City of Albuquerque

RE: RETAINING WALL BETWEEN LOTS 9 & 10, CAMBRIDGE PARK
SUBDIVISION (H-23/D31)

RE: CAMBRIDGE PARK DRAINAGE PLAN

REF: CAMBRIDGE PARK CONSTRUCTION PLAN CERTIFICATION (H23-D13)

CITY OF ALBUQUERQUE					
MUNICIPAL DEVELOPMENT DEPARTMENT					
ENGINEERING DIVISION					
TITLE: CAMBRIDGE PARK					
DETAILS					
APPROVALS	ENGINEER	DATE	APPROVALS	ENGINEER	DATE
City Engineer			Liquid Waste		
A C E - Design			Traffic		
A C E - Hydrology			Water		
DRAWING NO.			SHEET 8 OF 8

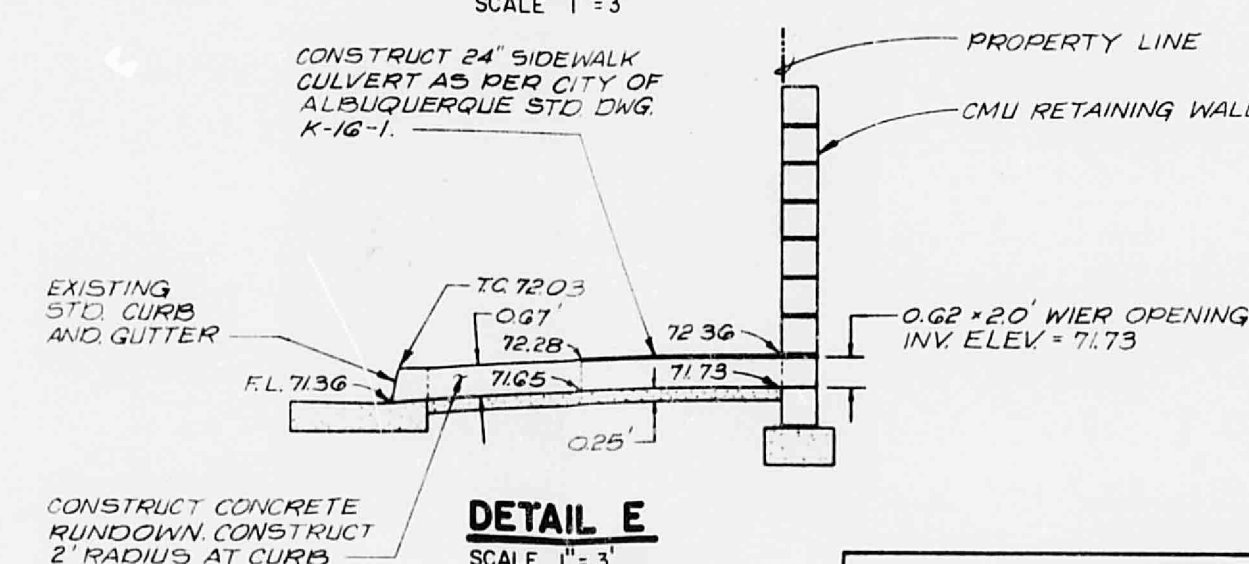
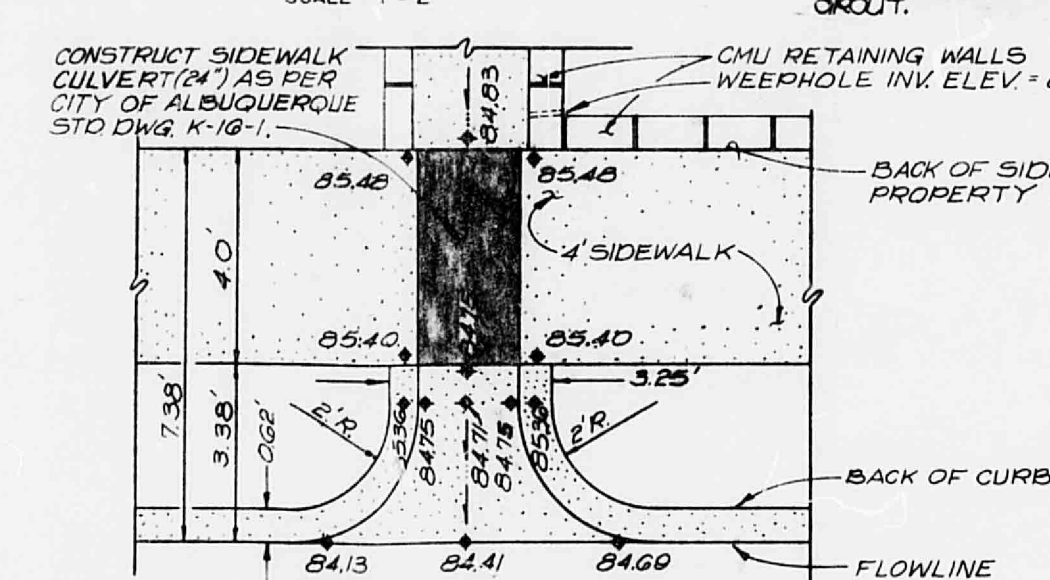
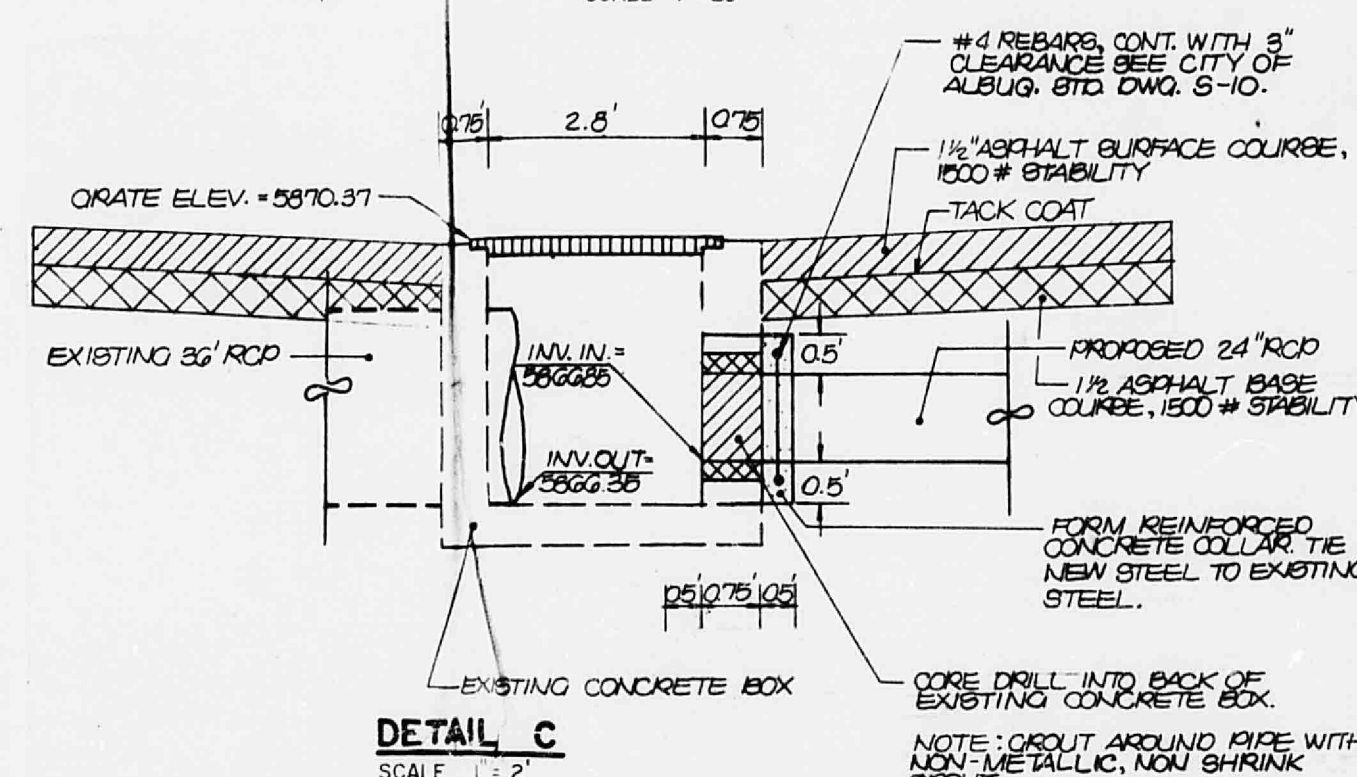
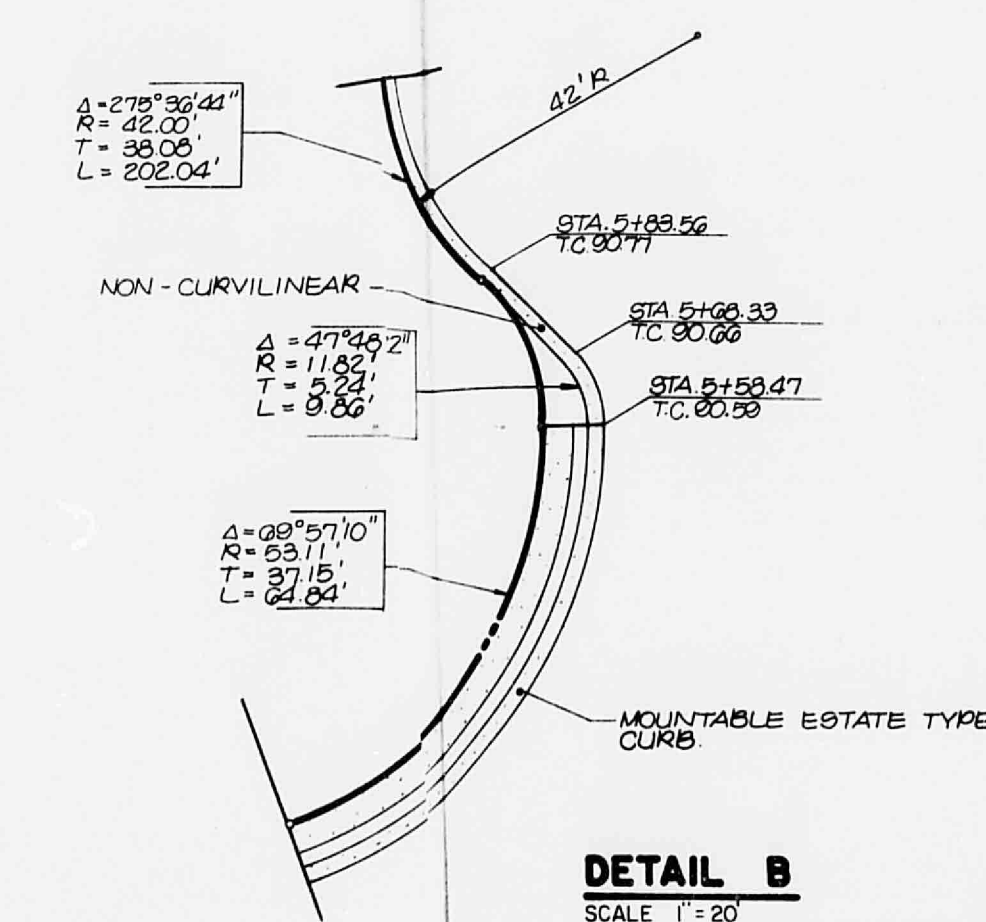
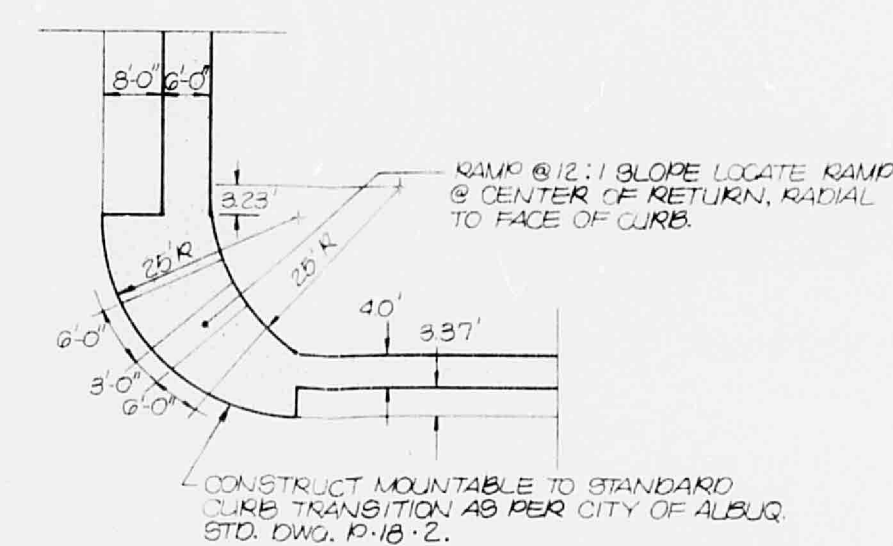
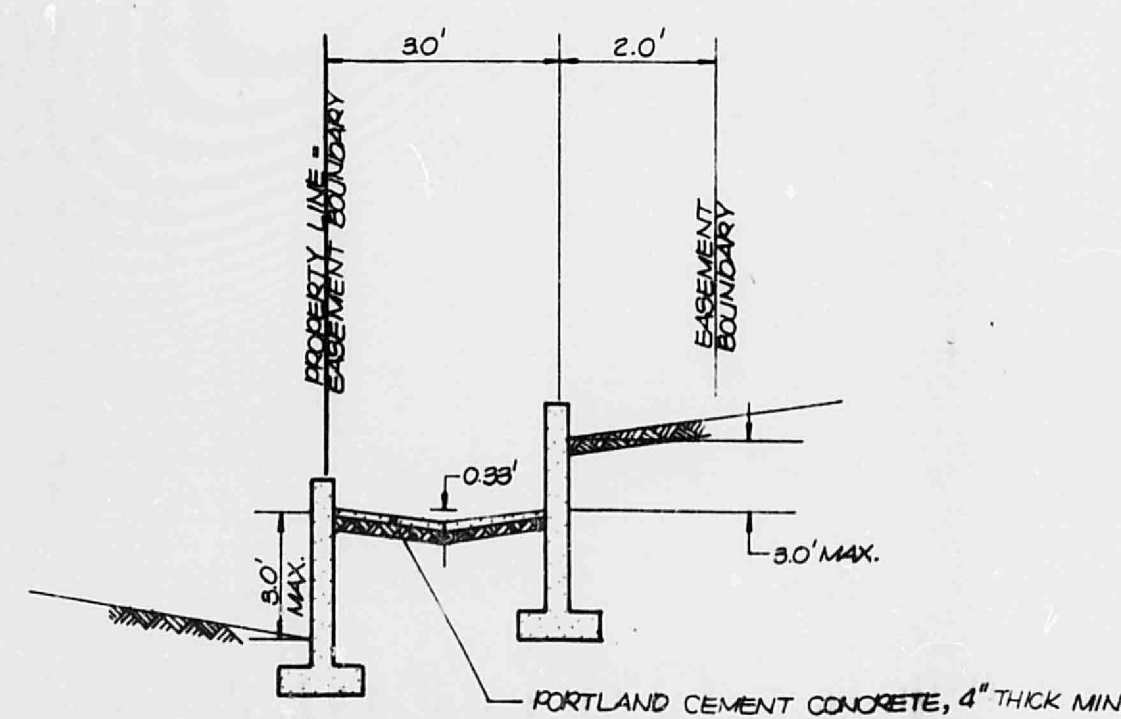
- a. Section C-C: What freeboard is provided by the lower wall?
 - b. Section D-D indicates that the lower wall extends higher than the adjacent ground. Will runoff stand behind this lip? Would it be appropriate to construct a swale behind the wall and provide several notches in the wall for runoff?

Item 4a: See attached detail sheet.

Item 4b: The area between walls, approximately 3', will be landscaped. The amount of runoff, we feel, will be negligible.
